TfNSW Reference: SYD21/00418/04  
Departments Reference: SSD-16928008

**EXHIBITION OF EIS – NEPEAN HOSPITAL REDEVELOPMENT PROJECT - STAGE 2 - 35-65 DERBY STREET, KINGSWOOD**

Reference is made to your correspondence seeking comment from Transport for NSW (TfNSW) on the supplementary Response to Submissions (RtS) for the above-mentioned State Significant Development (SSD-16928008).

Attachment 2 – Kitchen Dock Swept Paths

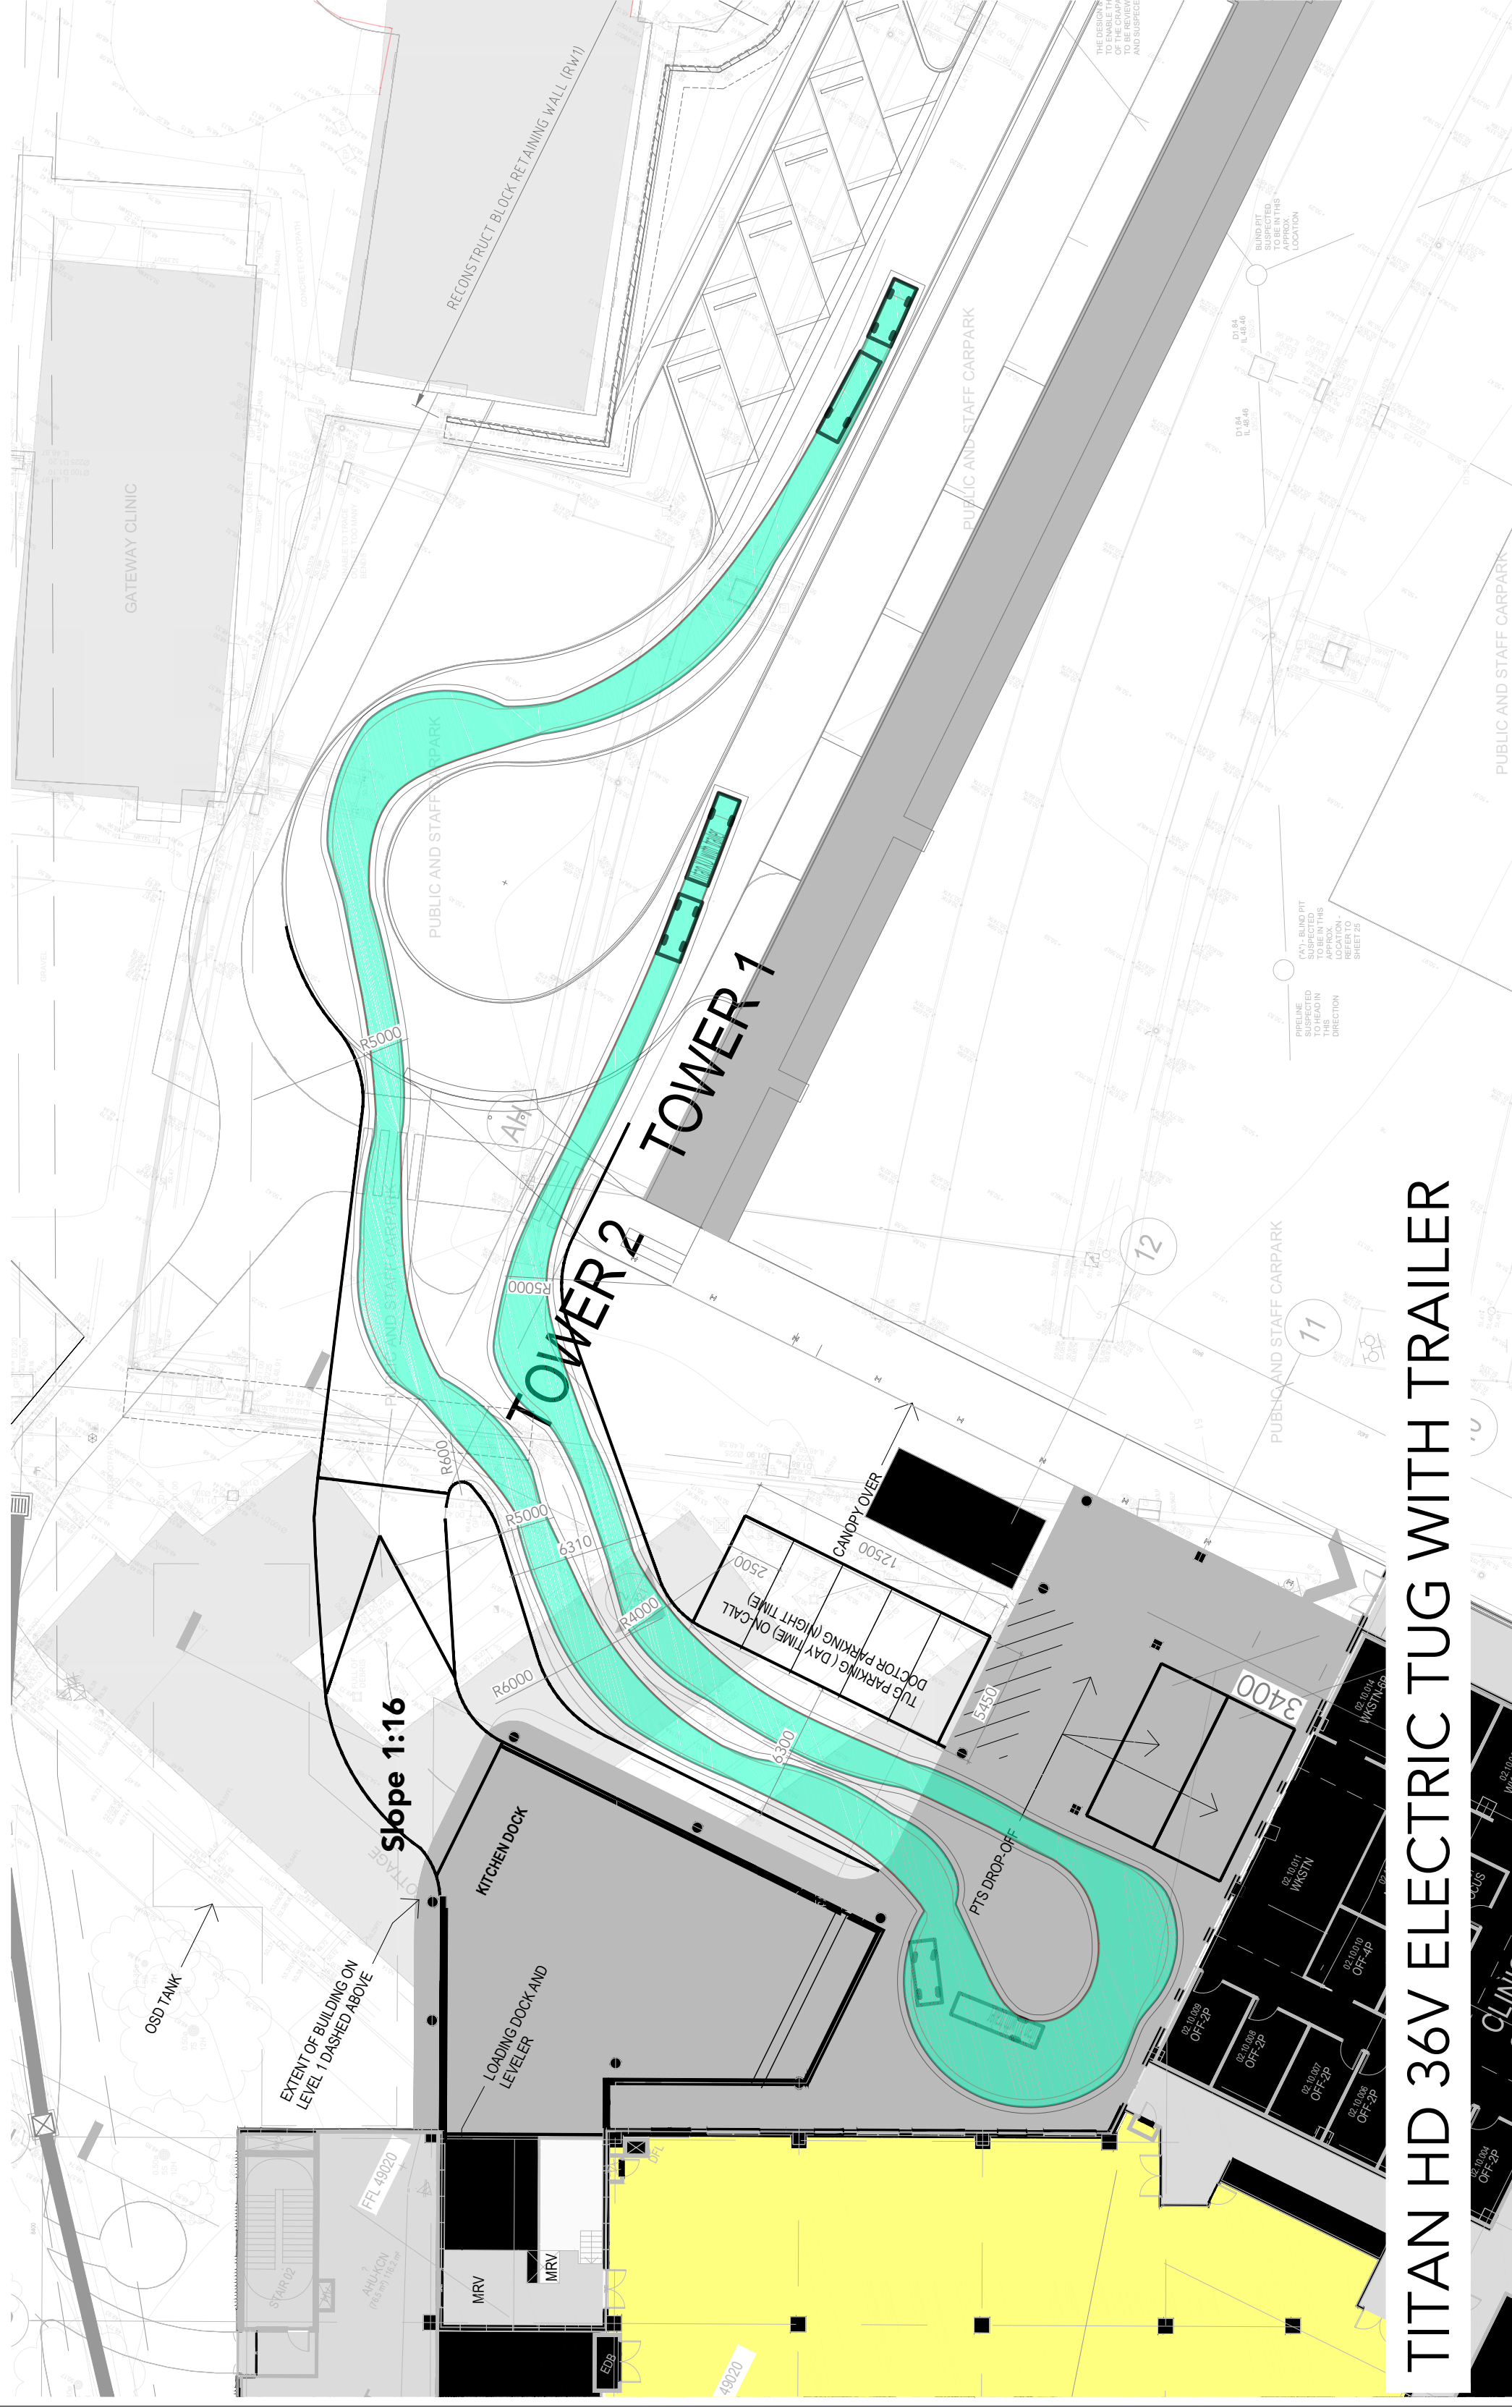
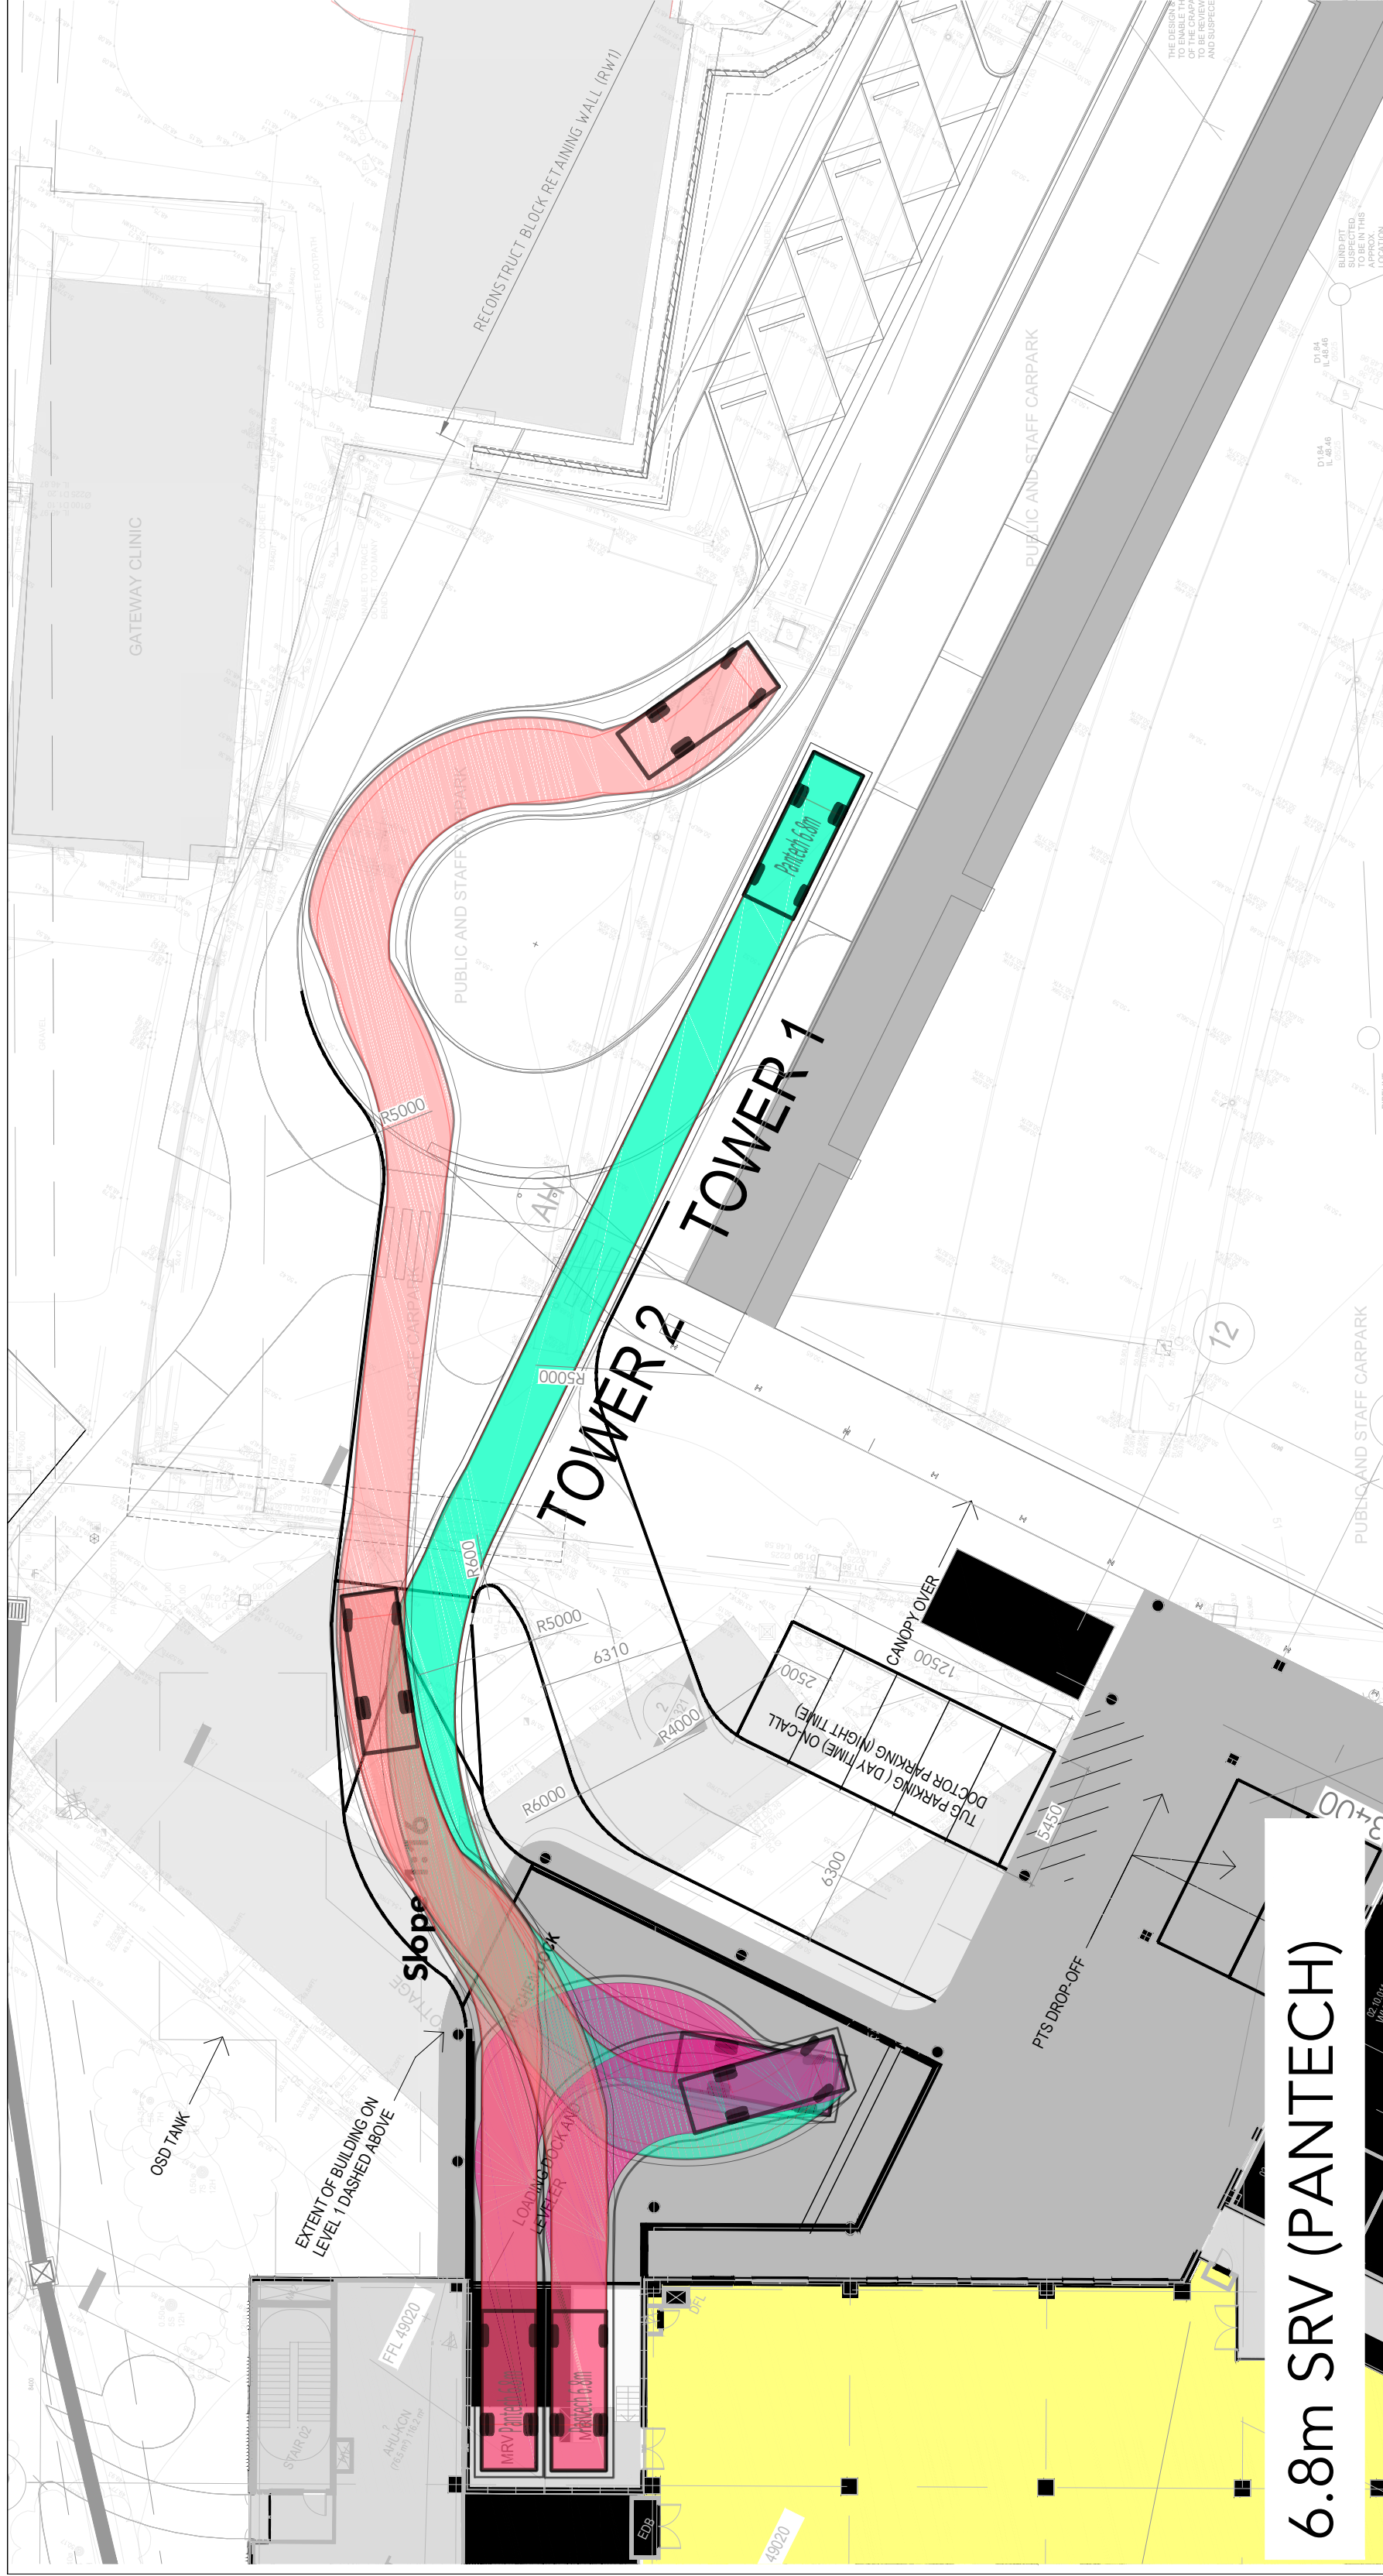
- The swept paths have been updated but appear to have incorrect attachment headings.
- The revised line marking plans do not include line marking;
- Confirm that swept path analysis referred to on page 2 is for Derby Street as previous Transport comments incorrectly referred to access road on Drawing #04T\_003 as Barber St.

TfNSW requests the abovementioned information to be addressed/provided for further assessment prior to the determination of the application. TfNSW will further review and provide response upon receipt of the additional information.
